Application Ref:	3/2025/0720			 Ribble Valley Borough Council www.ribblevalley.gov.uk				
Date Inspected:	N/A	Site Notice:	08/10/2025					
Officer:	MC							
DELEGATED ITEM FILE REPORT:					APPROVAL

Development Description:	Proposed demolition of existing holiday let chalet and replacement with one single-storey two-bedroom holiday-let. Alterations to existing access and with replacement entrance gates and fencing and creation of parking area.
Site Address/Location:	Hazelmere, Longridge Road, Hurst Green, BB7 9QP

Proposed Elevations

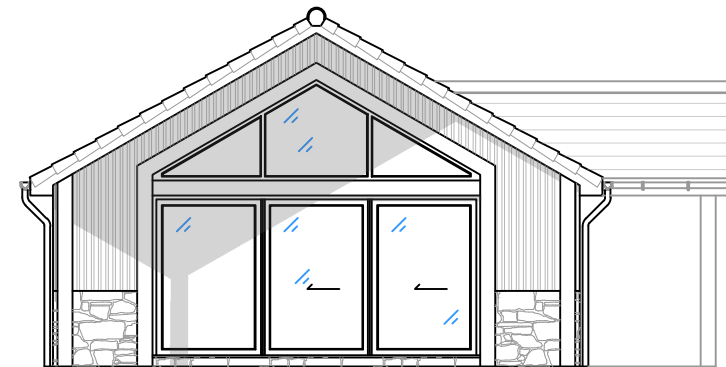
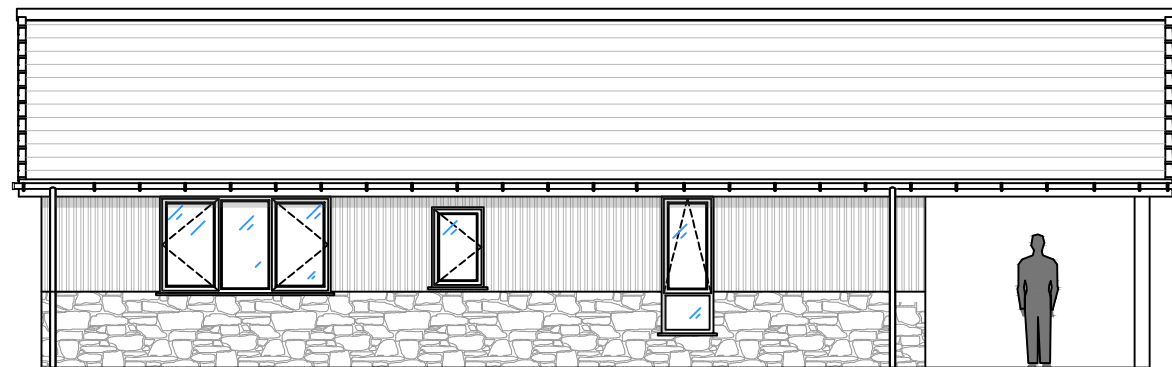
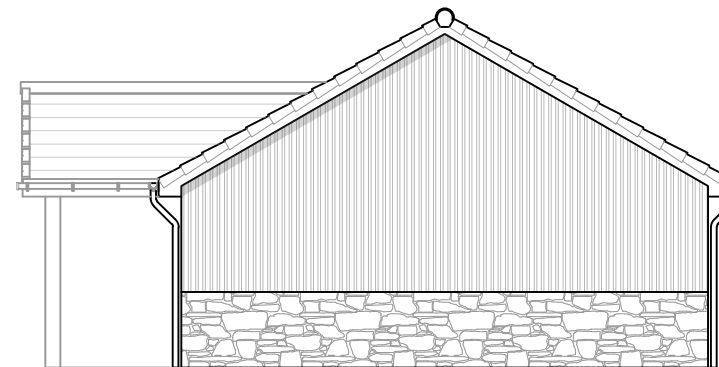
The holiday let would have a dual pitched roof with an eaves height of approximately 2.5 metres and a total height of approximately 4.7 metres. The application form indicates that the external walls would be constructed of stone and timber with slates to the roof. In addition, a small amount of glazing has been removed to the front elevation prior to determination.

The size, siting and design of the holiday let is mostly the same as the refused scheme, however the glazing to the south elevation has been marginally reduced by increasing the frame thickness. The roof material has also been amended to slate which is considered to be more appropriate than the previously refused scheme of standing seam.

DRAWING TITLE:
Proposed Entrance Elevation

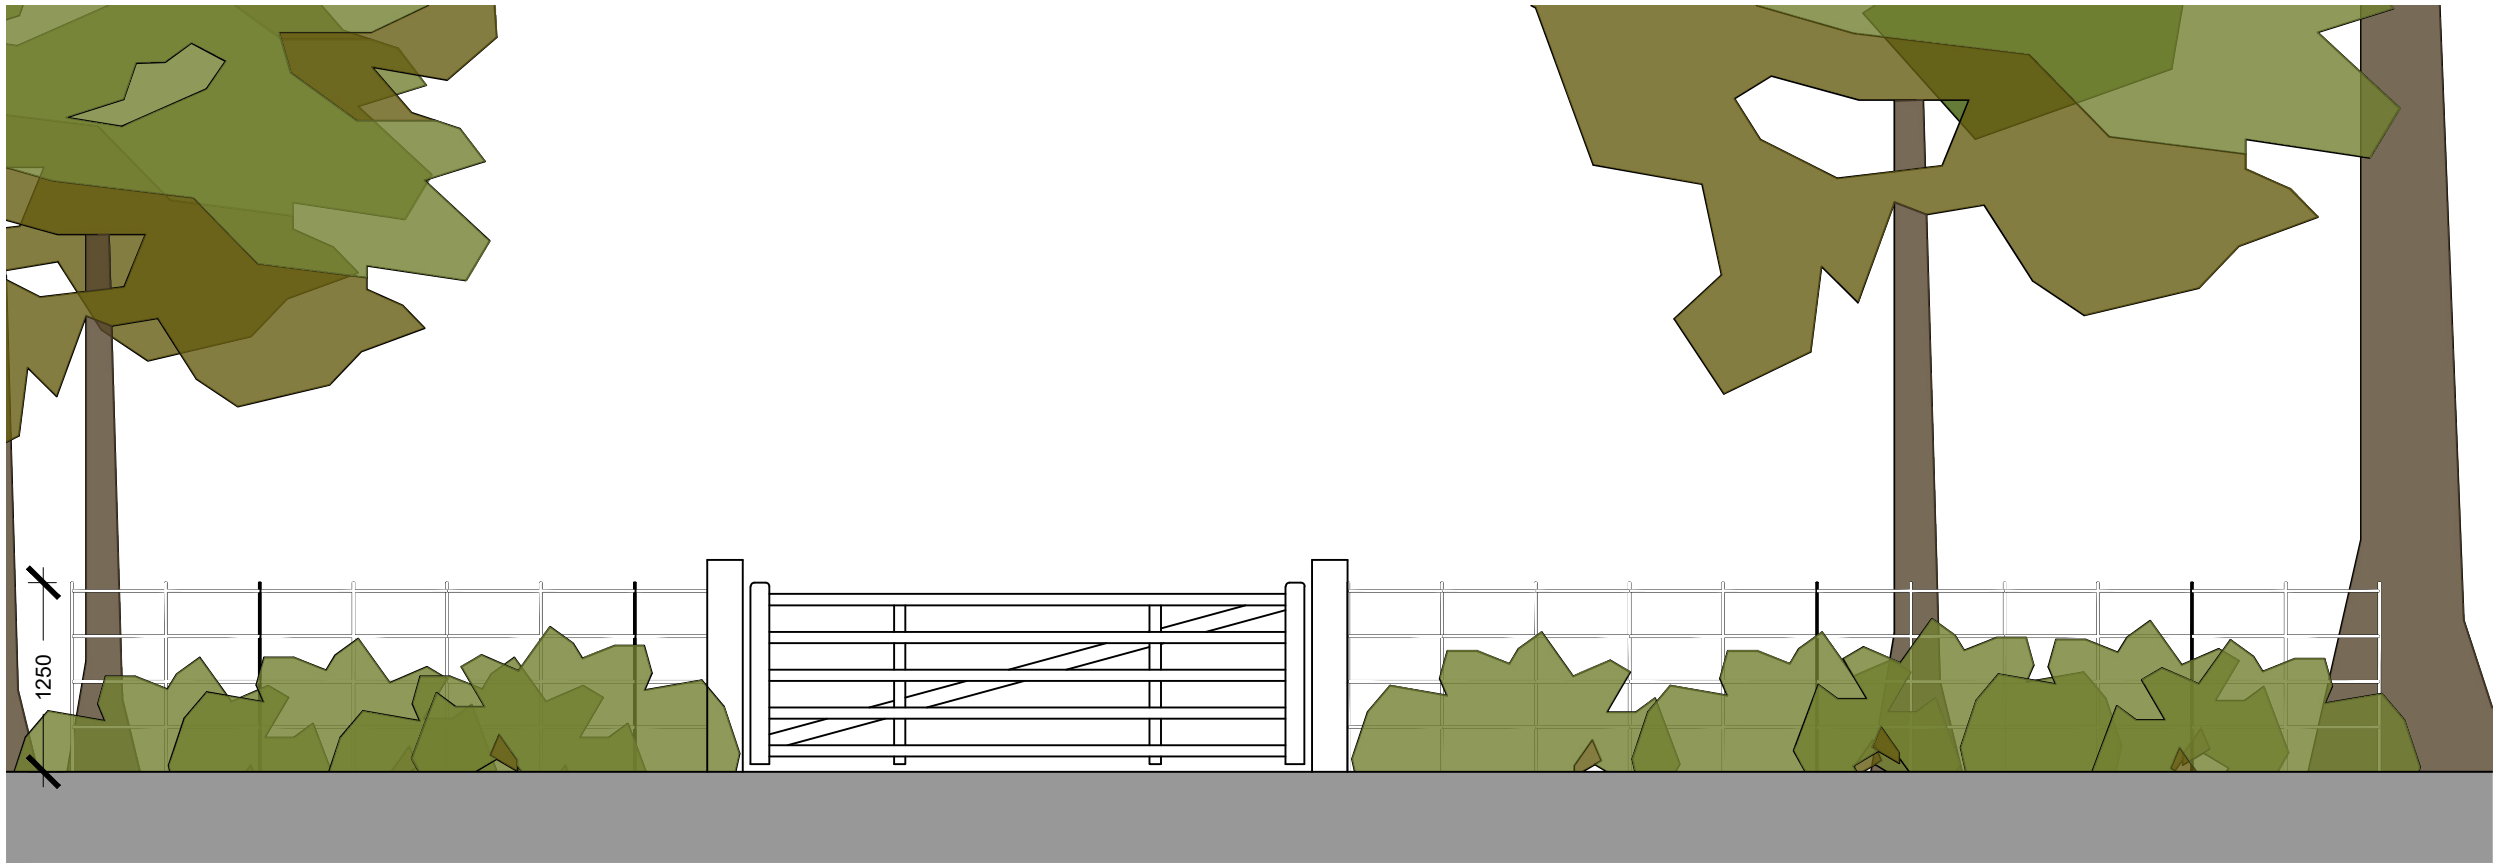
The proposal also includes the creation of a new parking area to the front of the site as well as new entrance gates which would now be a timber gate with a maximum height of approximately 1.4 metres.

The proposal would include the demolition of the existing gates and erection of new entrance gates which would now be similar in appearance to the open timber existing gates. This is considered more appropriate

to the rural character of area and would not have such a domestic and urban appearance when compared to the previously refused scheme. In addition, the hardstanding for the car parking area has been reduced in size and the proposed bin store would be sited to the east of the driveway in a more discreet location.

**Pre-Development Plan
Baseline Map**

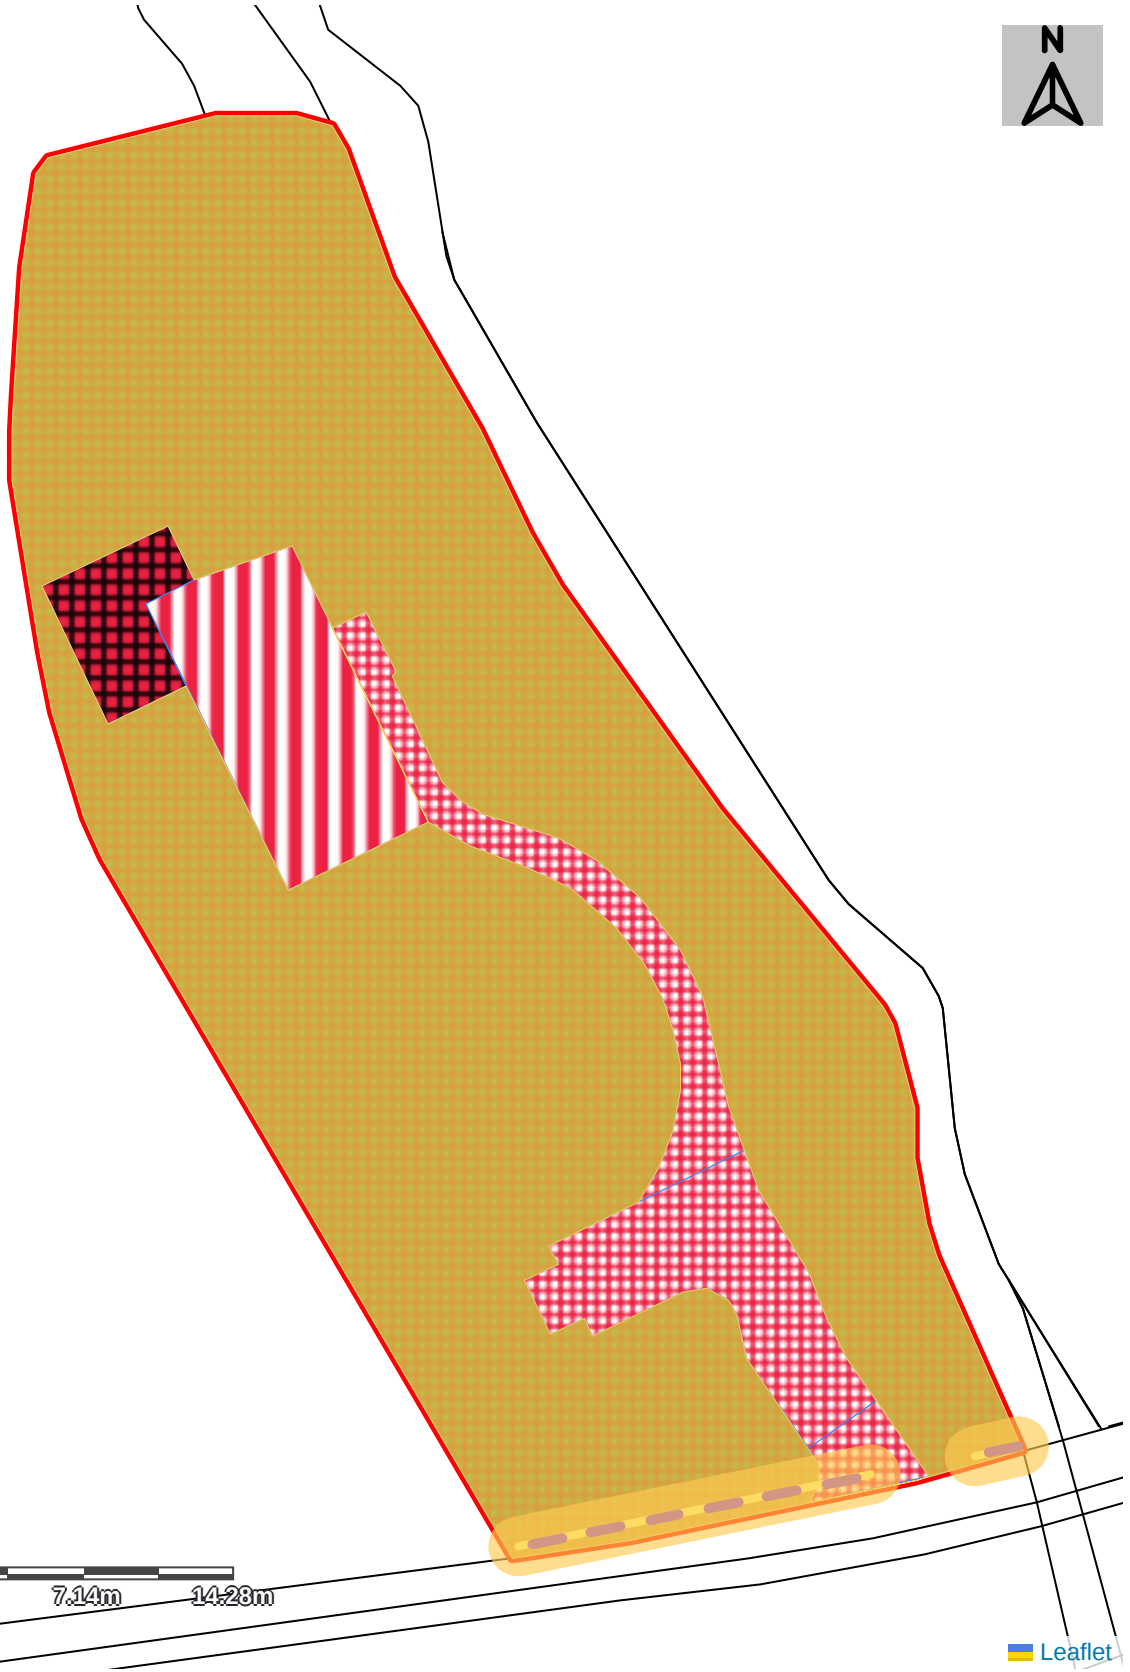
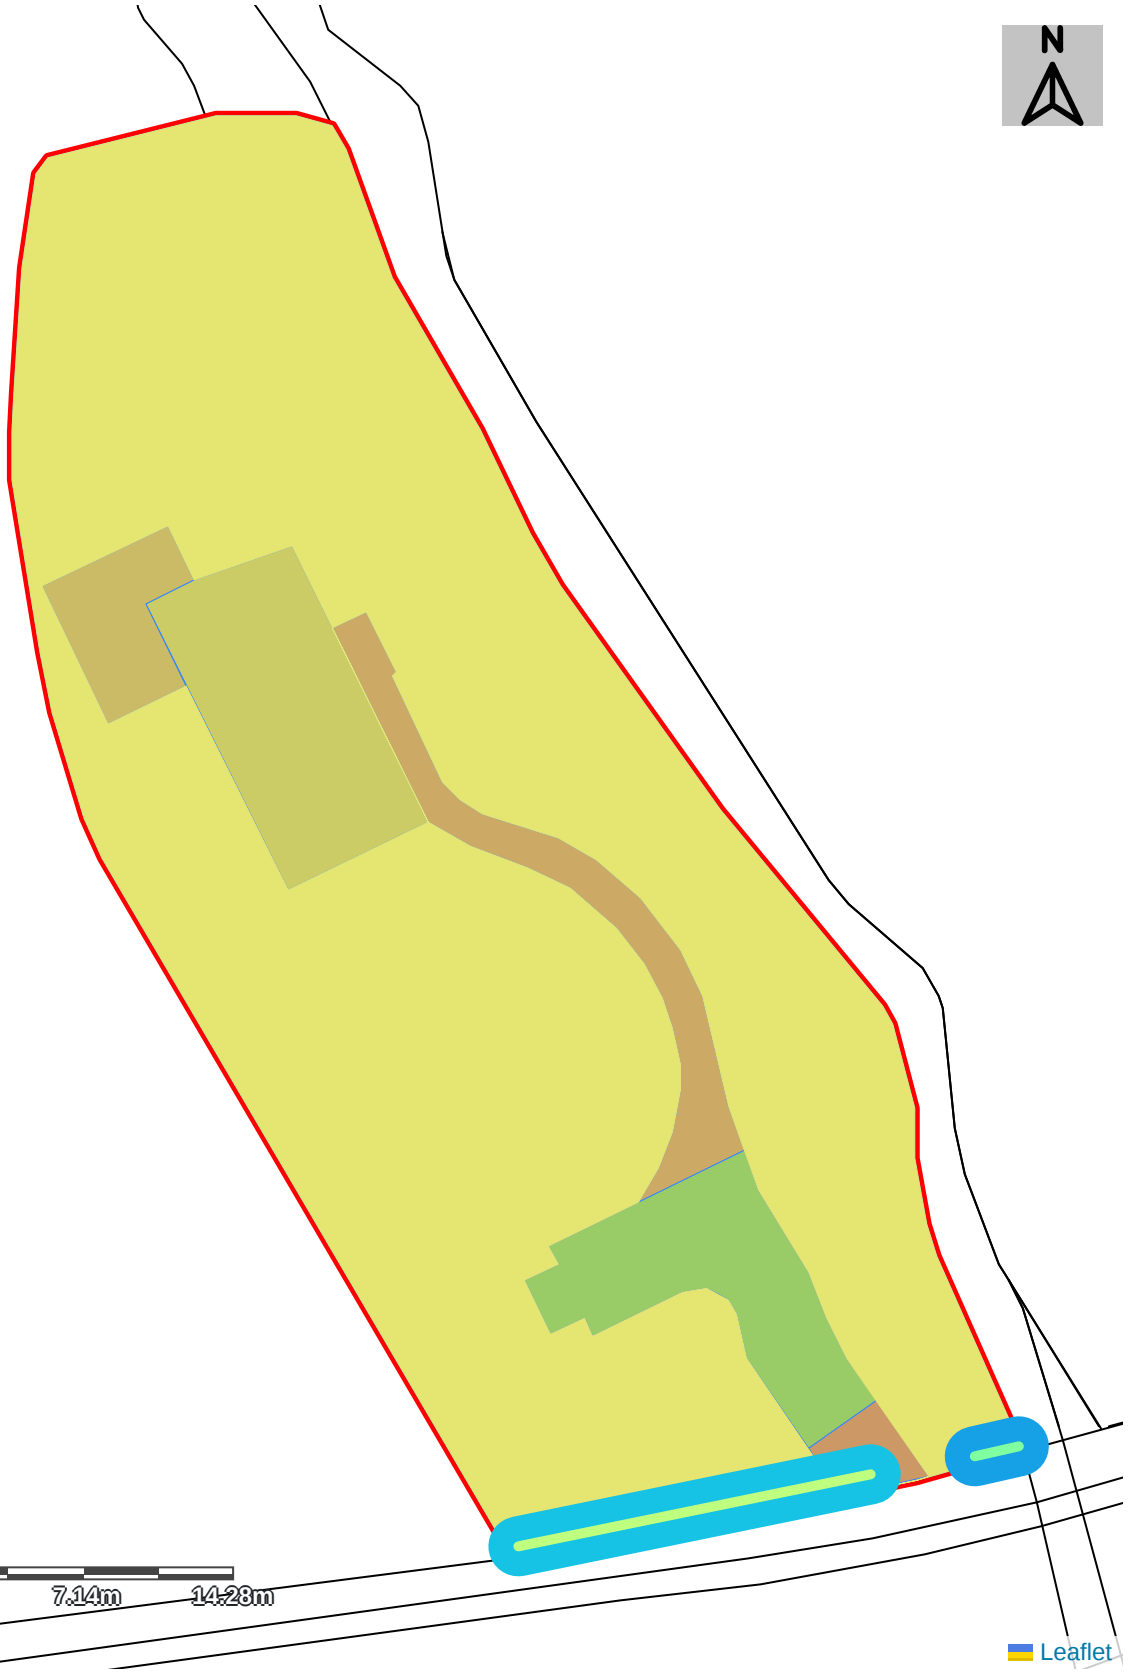
Turing to biodiversity net-gain, the biodiversity metric states that there would be a hedgerow unit increase of approximately 43.36% and area habitat unit increase of approximately 13.83%.

The Ecologist has not commented on this application. However, the Council are satisfied that 10% BNG can be achieved on site (which includes additional woodland planting within the site and enhancement of the existing hedgerow). No specific details have been provided to demonstrate the number/type of new trees/hedgerow and as such, as part of the pre-commencement Biodiversity Gain Condition which will apply to the application, further information should be submitted in an updated Biodiversity Gain Plan concerning on-site landscaping to achieve the gain. A habitat management plan should be required by condition to secure the sustainable future of the enhanced habitats.
